Please ask for: Ms Iqraa Malik
Email: iqraa.malik@terraquest.co.uk
Telephone: 01212341390
Our Ref: EP/72/21/HH
Your Ref:
Date: 16th June 2021

Application for Planning Permission for Works or Extension to a Dwelling

Development: Erection of single storey side/rear extension following the demolition of existing garage, shed and conservatory
Location: 8 South Drive Felpham PO22 7PZ

WEST ELEVATION EXISTING 1:100

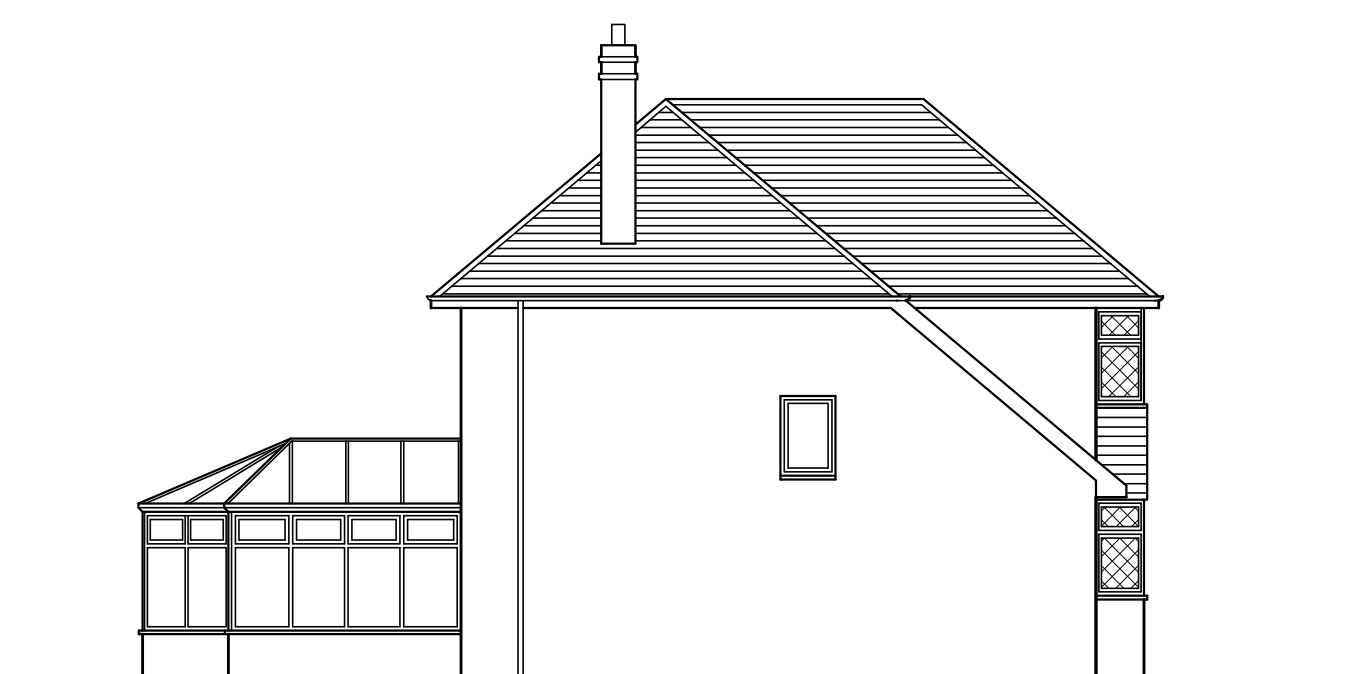
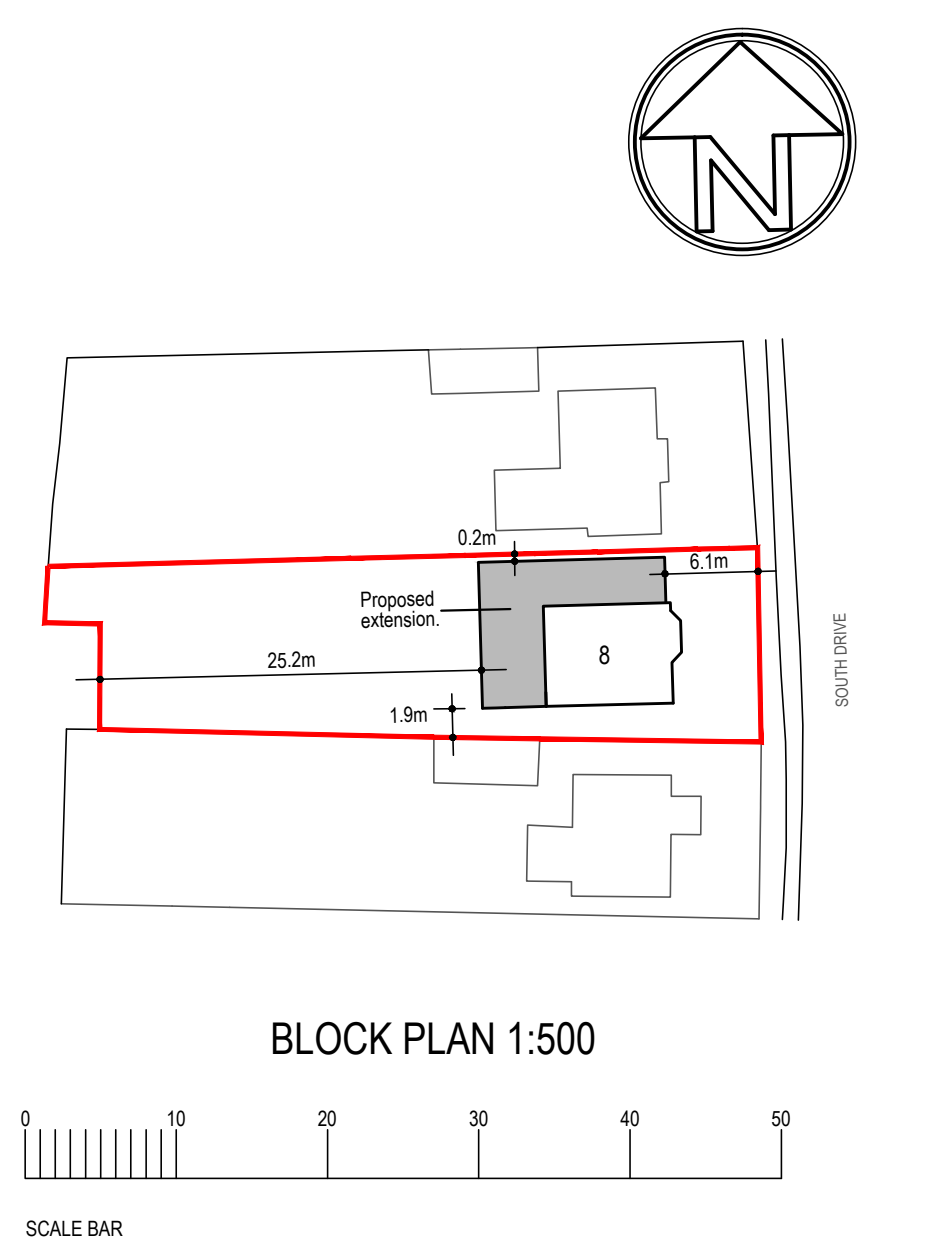
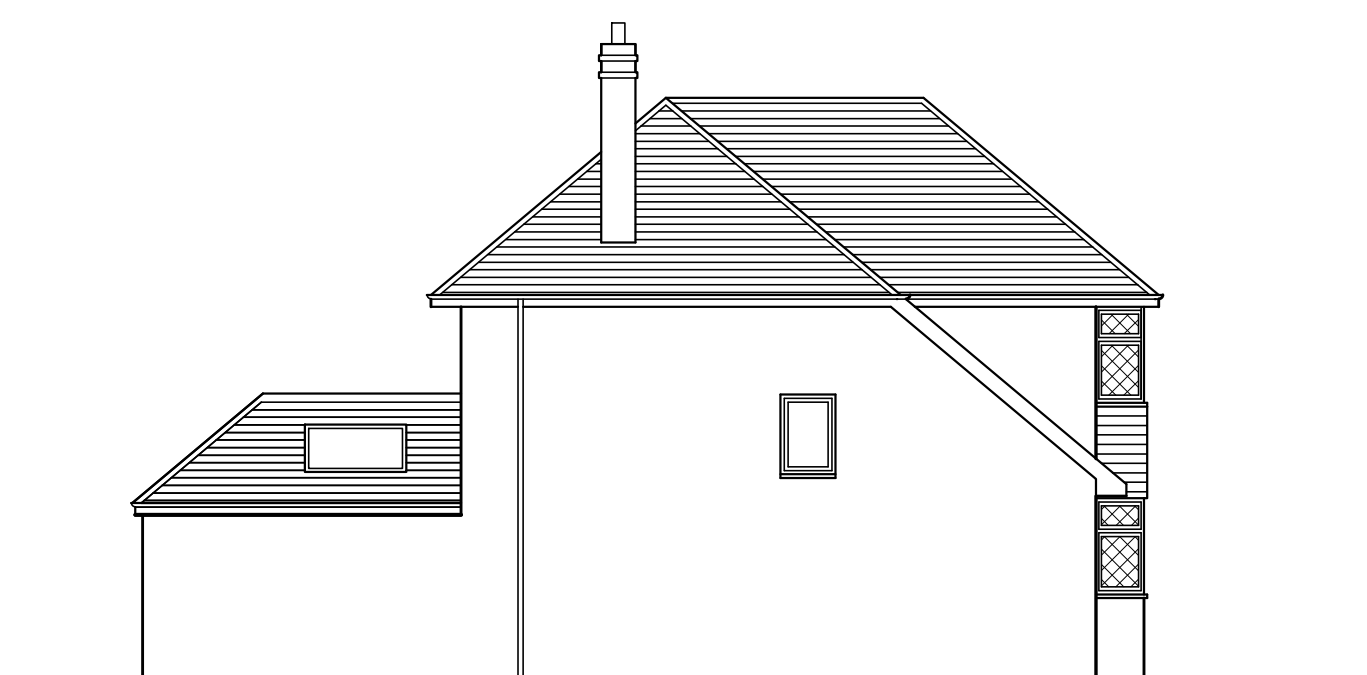
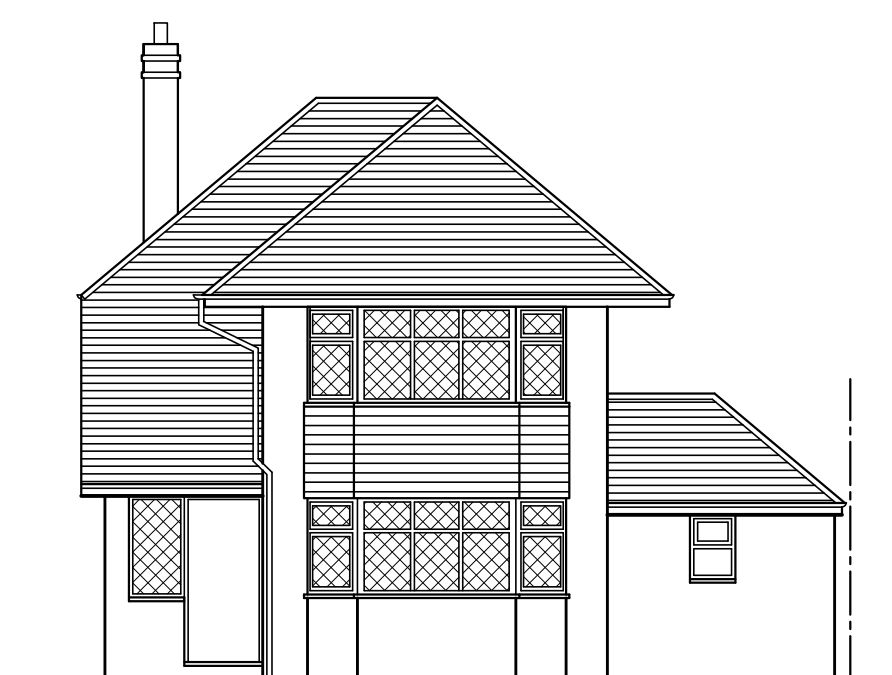
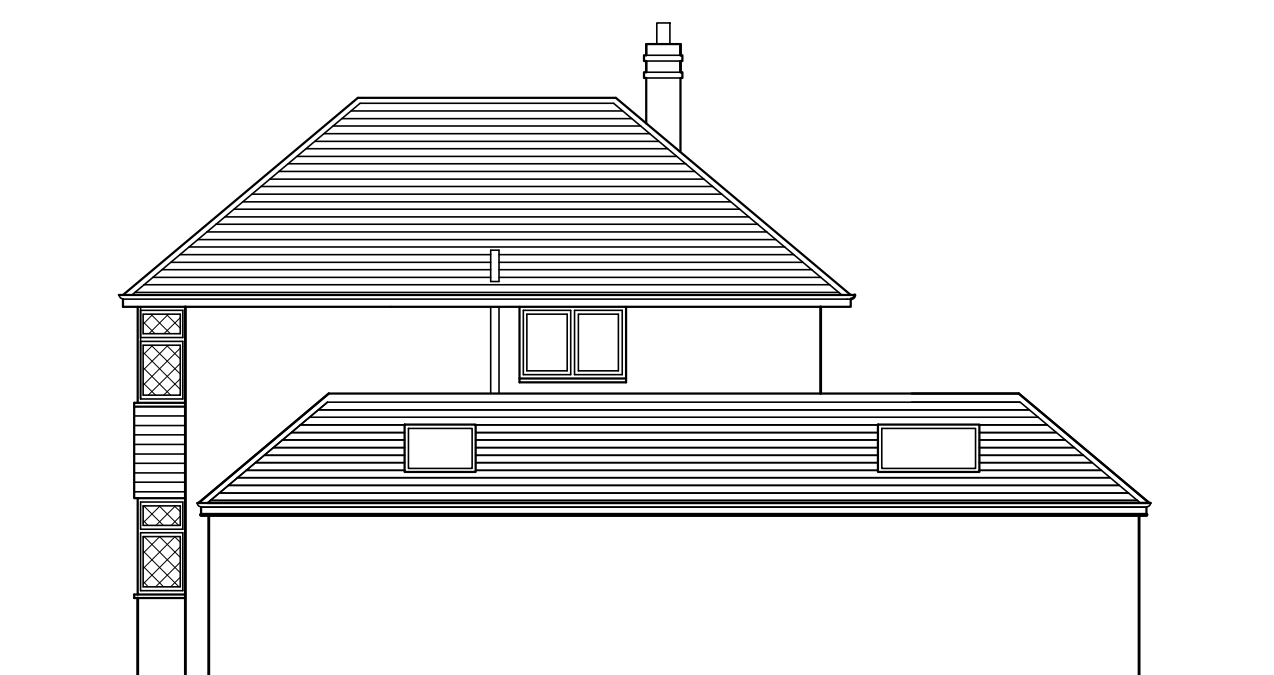
The existing and proposed west elevation is labelled as east. Please amend.
